## WEST SUSSEX COUNTY COUNCIL CONSULTATION

| <b>SUBJECT:</b>                 | BN/57/19/RES<br><br>Approval of reserved matters following the grant of<br>WA/22/15/OUT for a 2 No. non-residential buildings.<br><br>An amendment received. |
| <b>RECOMMENDATION:</b>          | More Information                                                                                                                                             |

DATE	DRAWING No.
04-02-20	1726

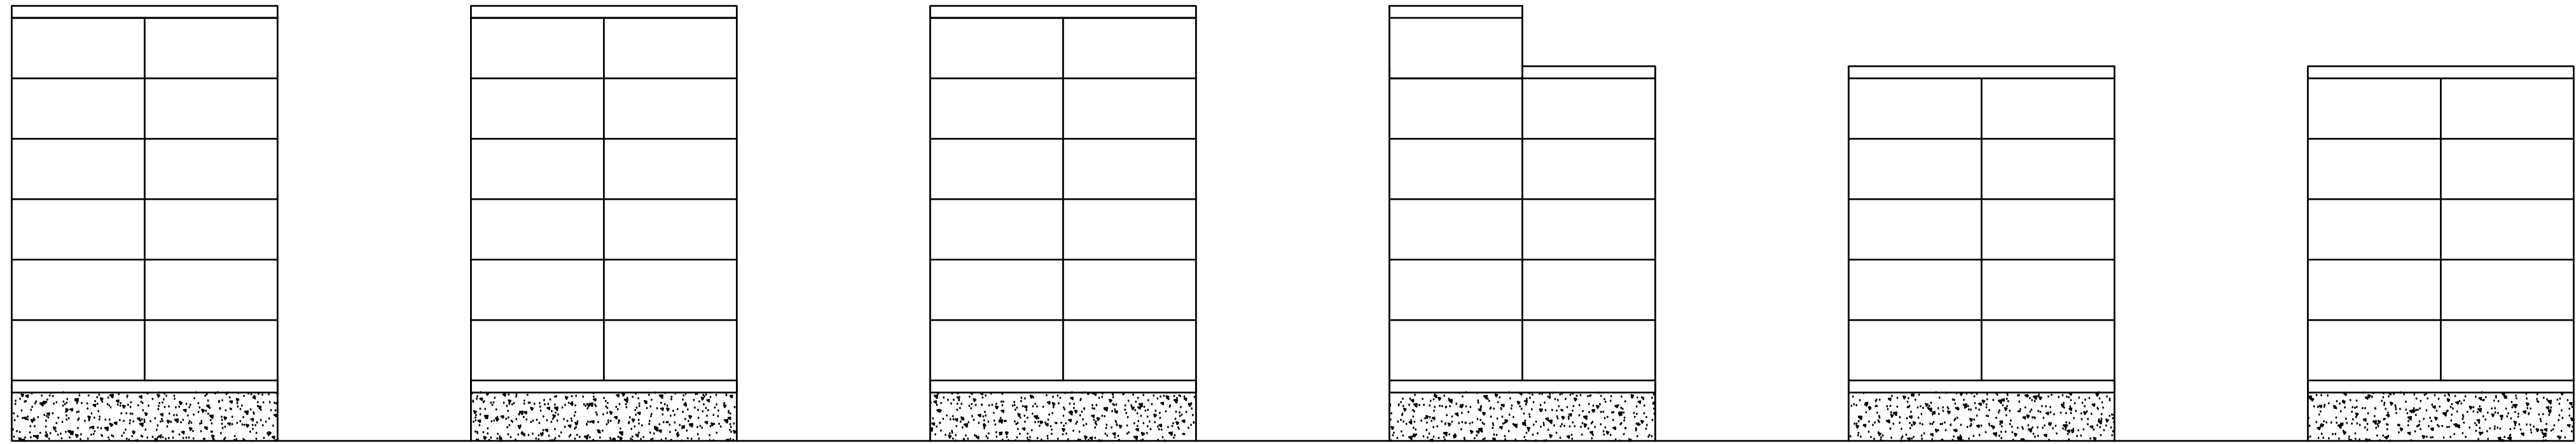
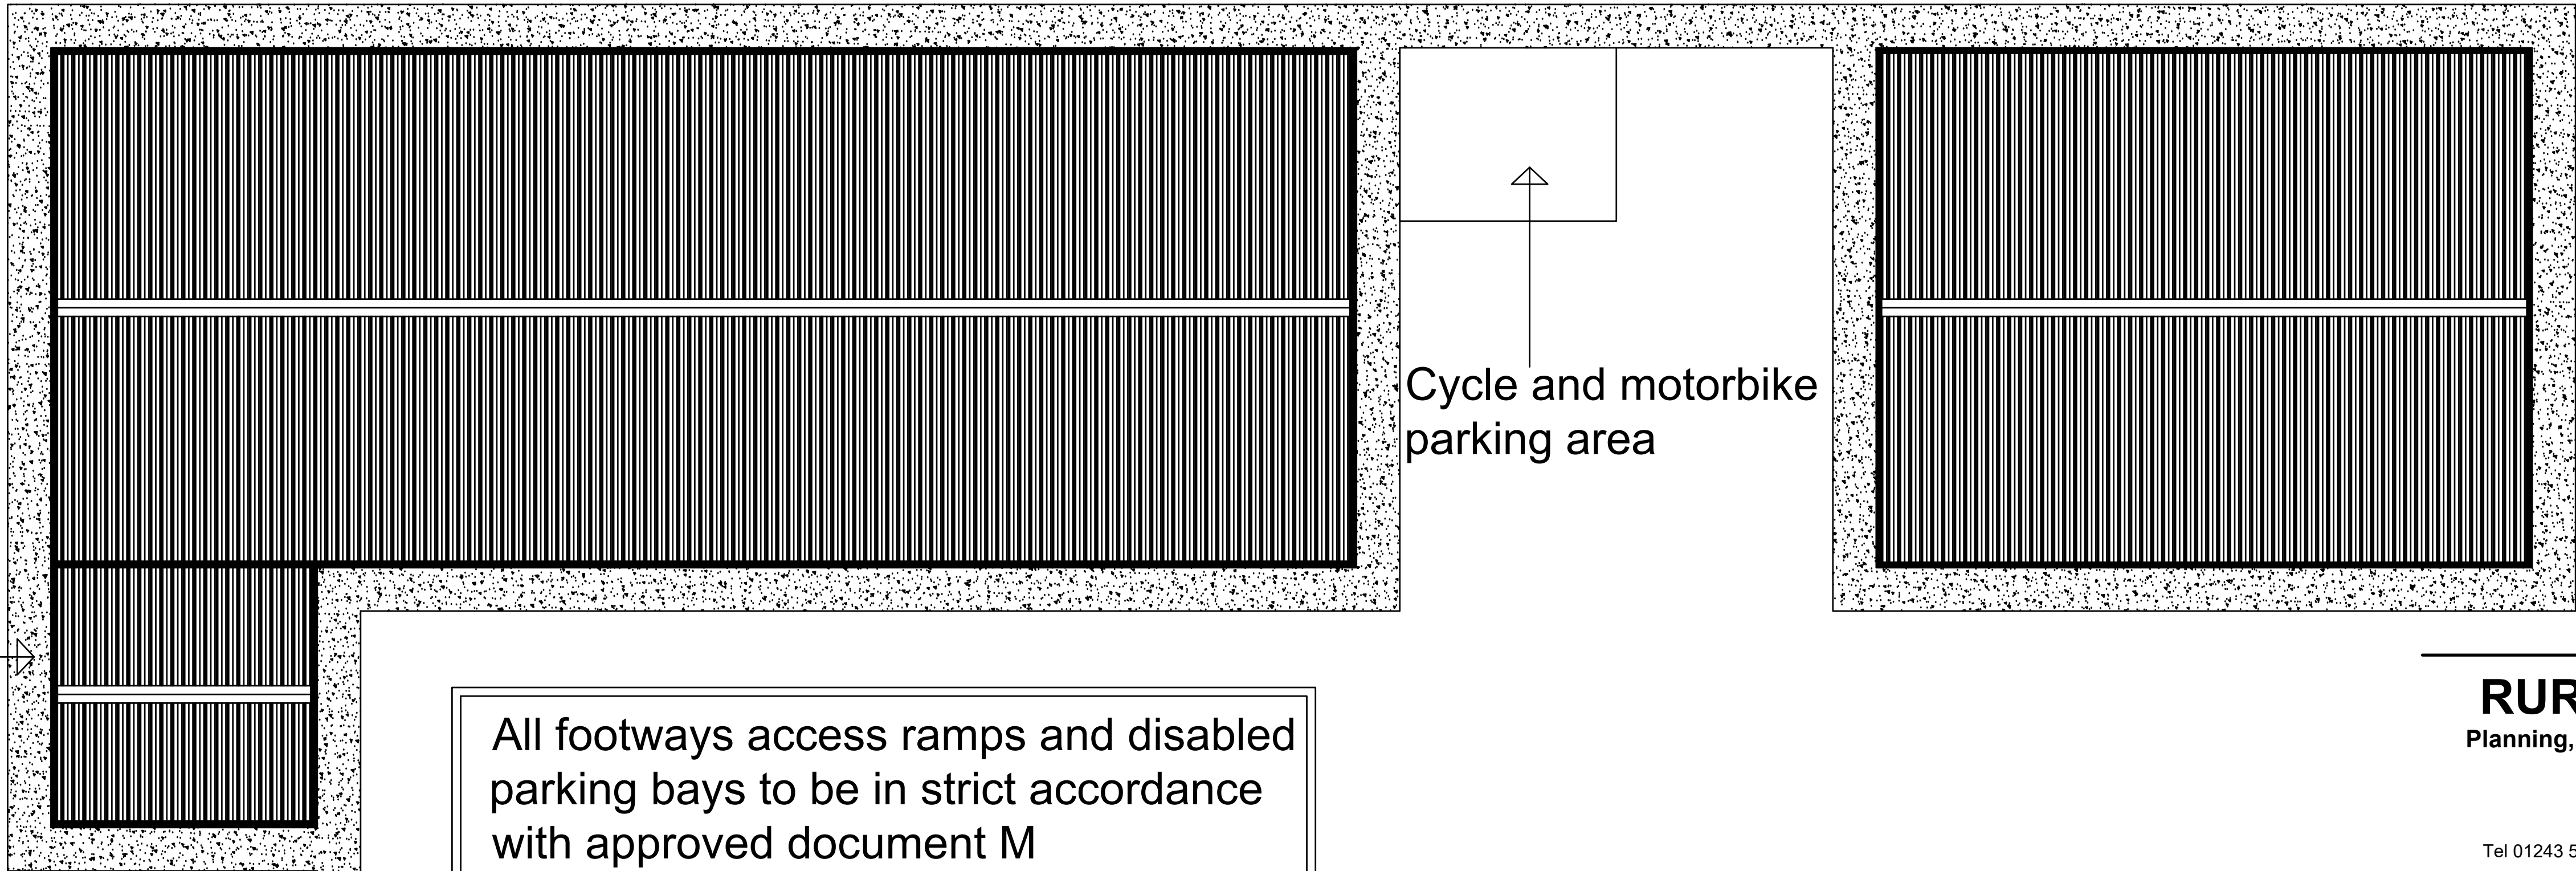
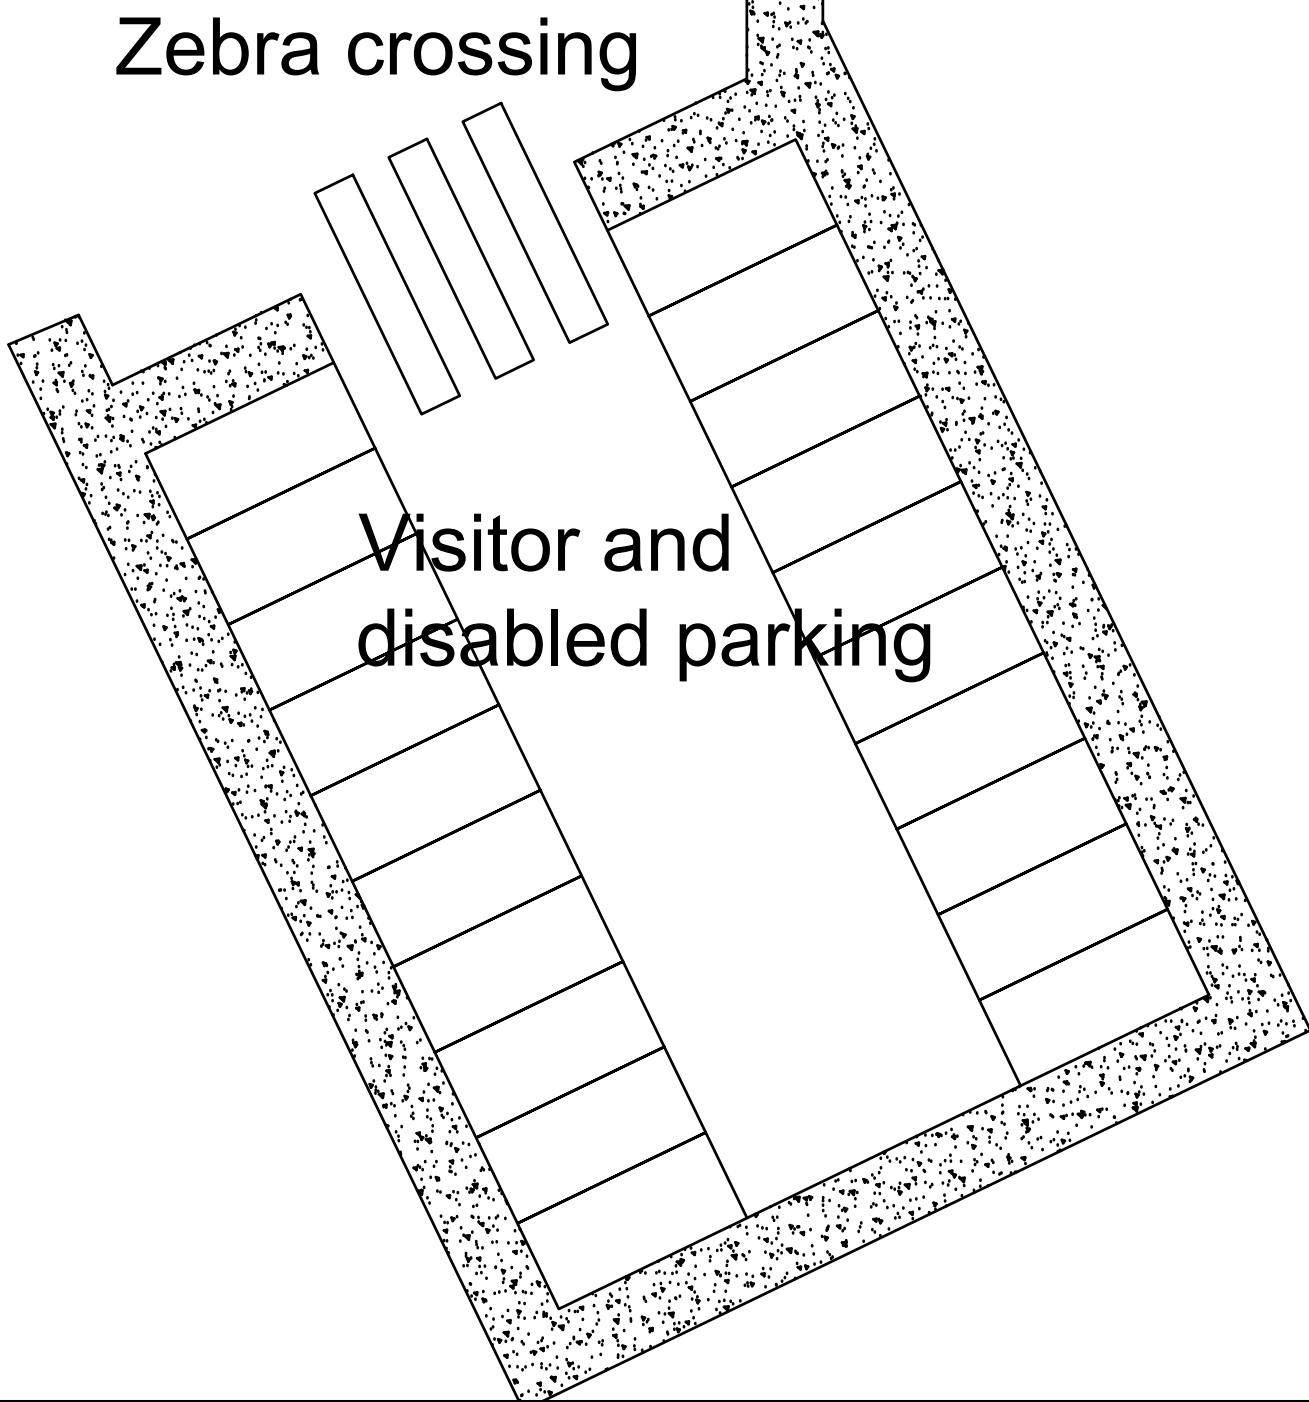
Approximately 85 parking spaces are to be provided which would be above the maximum parking standards included within the Arun Parking standards, it is noted the standards should be used as a guide and justification provided on a site specific basis. This has not been provided within the application documents

A combined cycle and motorbike parking area is shown on the plan titled - parking and access and numbered 1726 but no details of the number of cycle parking spaces are provided.

Addition details on vehicle and cycle parking levels and vehicle tracking should be provided.
